**Proposed Roundabout Access to Graven Hill and  
Wretchwick Green London Road Bicester**

**20/01830/F**

**Proposal:** Proposed roundabout junction

## **A. A41 Pioneer Road Roundabout Design**

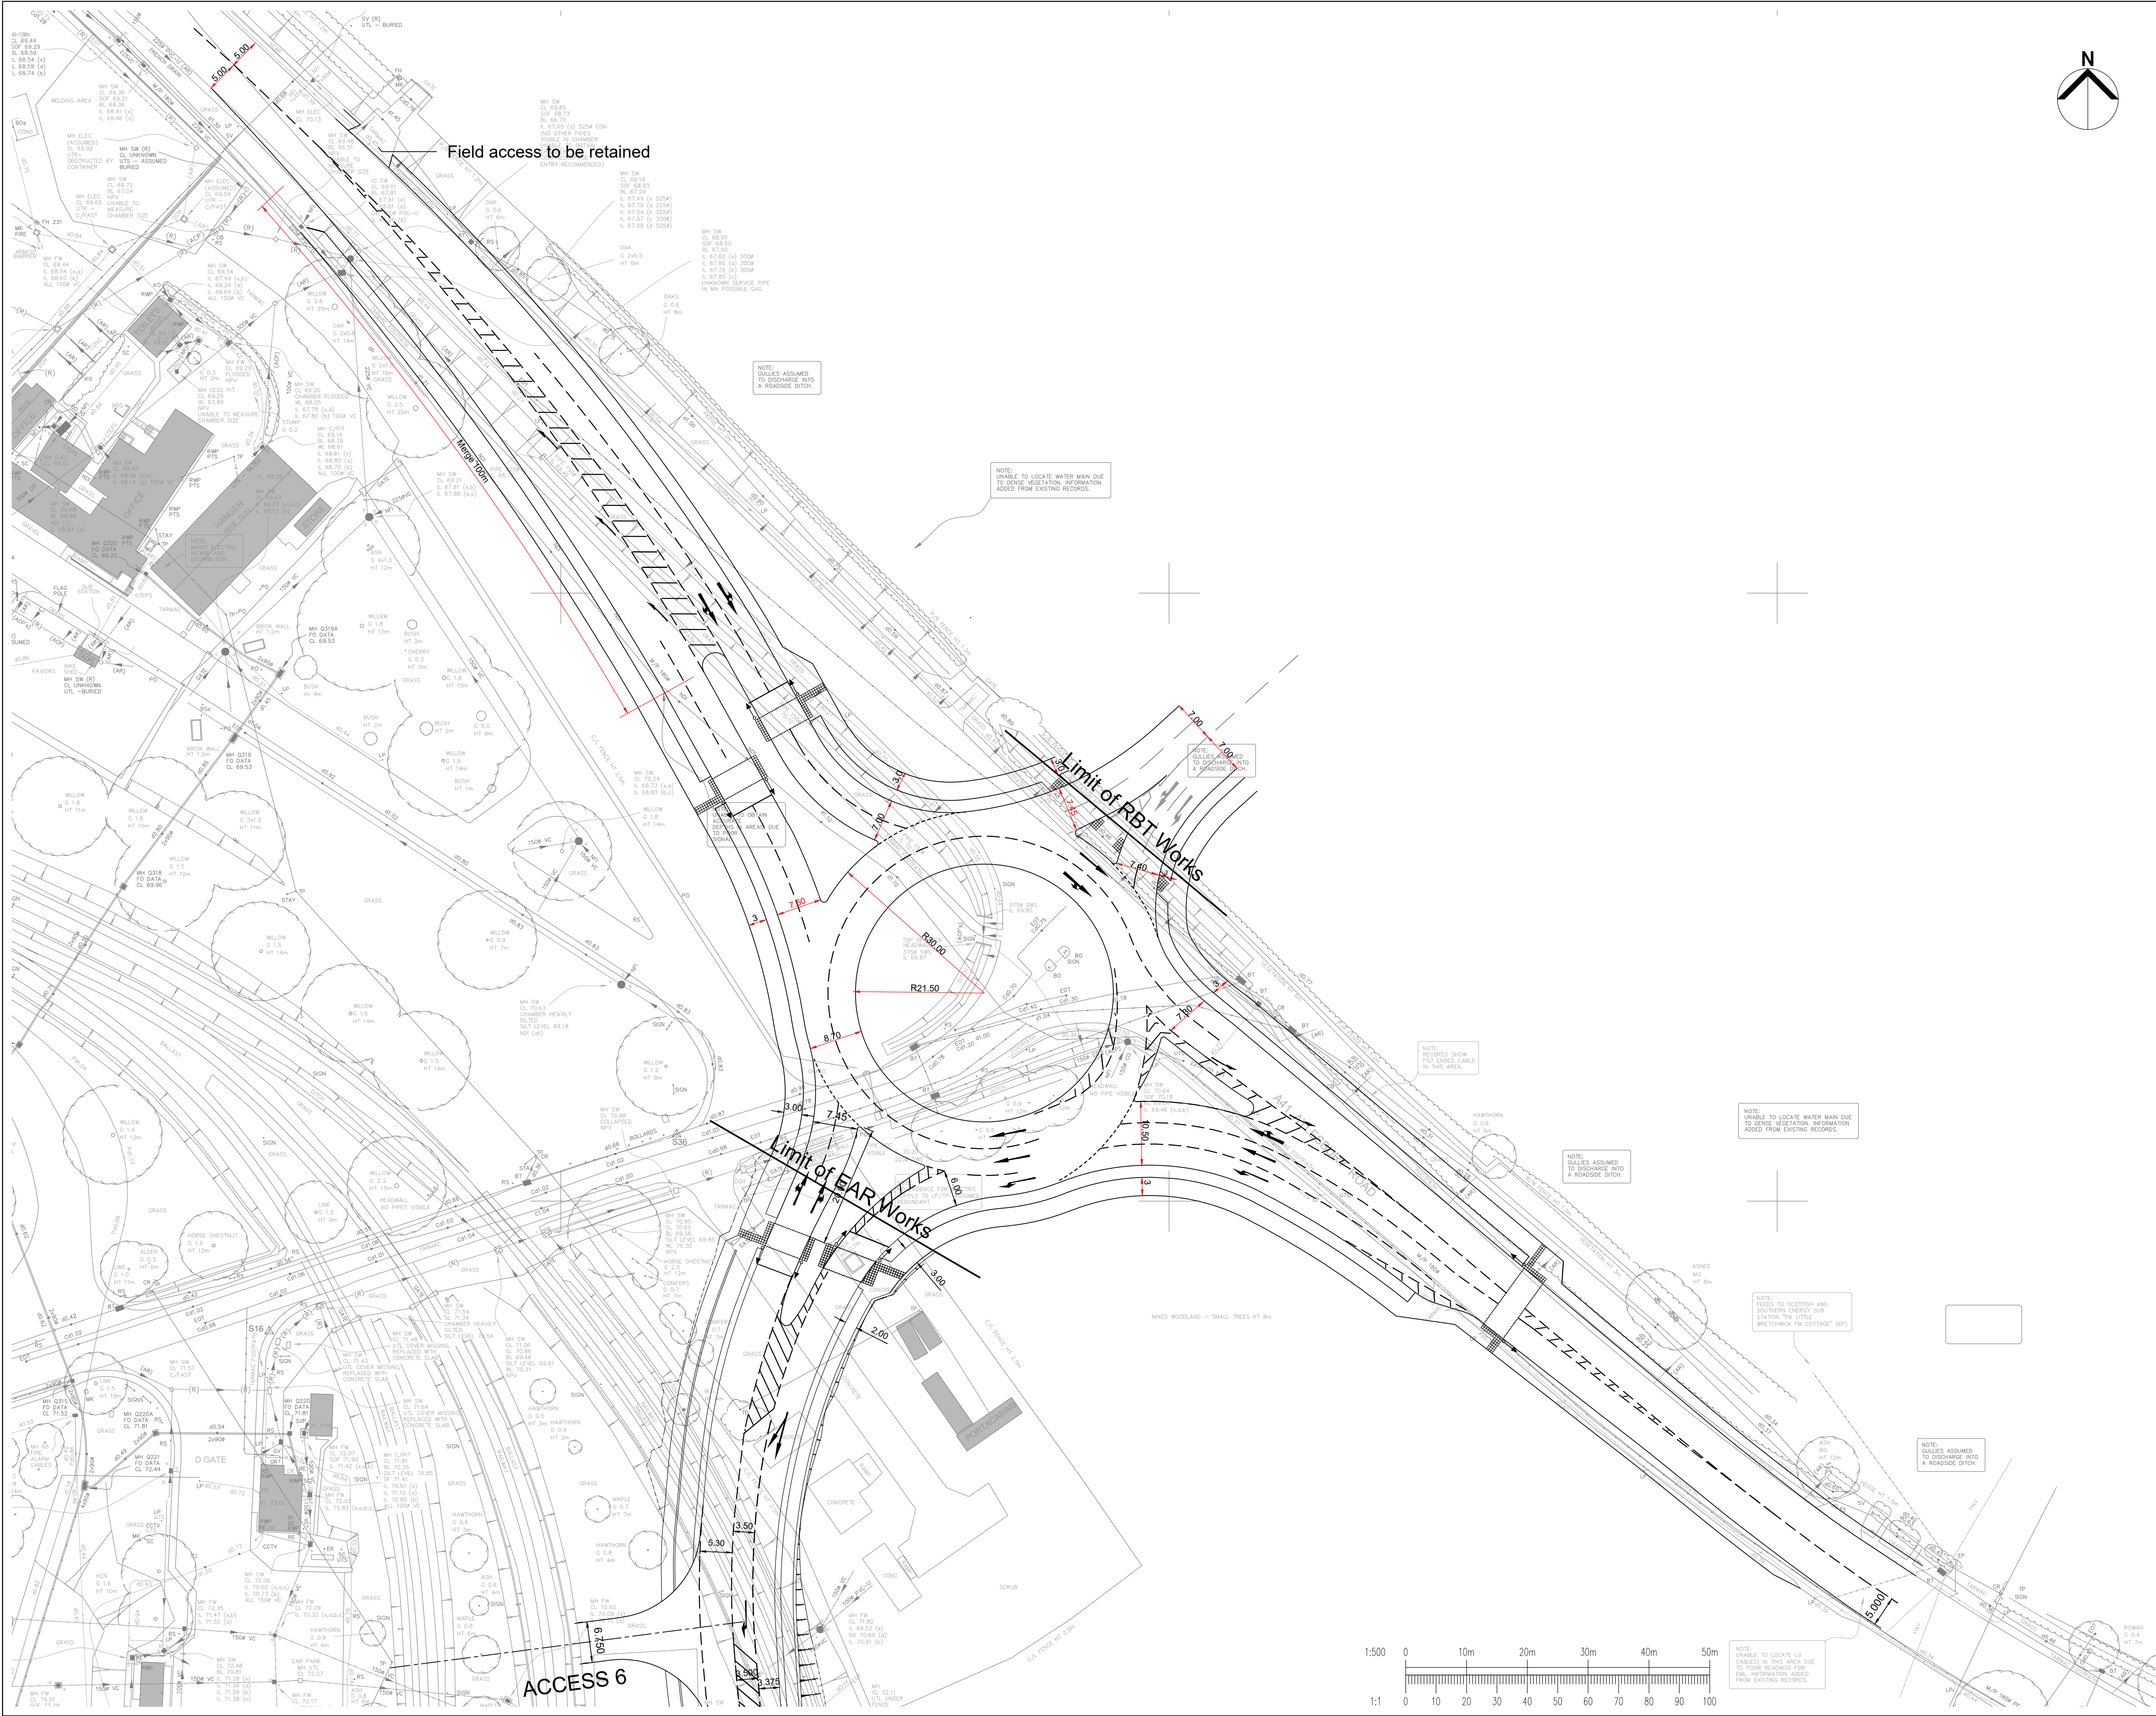
- Shared use ped/cycle facilities around the roundabout should conform to LTN 1/20 and therefore require to be segregated
- The signalised crossings should be straight across rather than staggered to minimise delay to pedestrian and cyclists.

*'The form of crossing also conforms to the latest Government guidance on Cycle Infrastructure Design (LTN 1/20), which was published on 27 July 2020. However, consideration should be given to making the staggered crossing on the A41 W arm into a single phase, to minimise delay to pedestrians and cyclists. I would like to see this tested.*

*The width of the shared use facility at the roundabout does not conform to LTN 1/20, which requires segregation between pedestrians and cyclists. It should be amended to conform to LTN 1/20 and to be consistent with the facilities planned on the new roads leading into Graven Hill and Wretchwick Green. Sufficient space should be allowed for pedestrians and cyclists to wait at the crossings without obstructing the path of passing pedestrians and cyclists.*

- 9.23. The Local Highway Authority consider that both of these points can be overcome through the submission of amended drawings. Amended drawings have now been submitted to address the points raised further comments from the Local Highway Authority are awaited and an update will be provided to the committee.
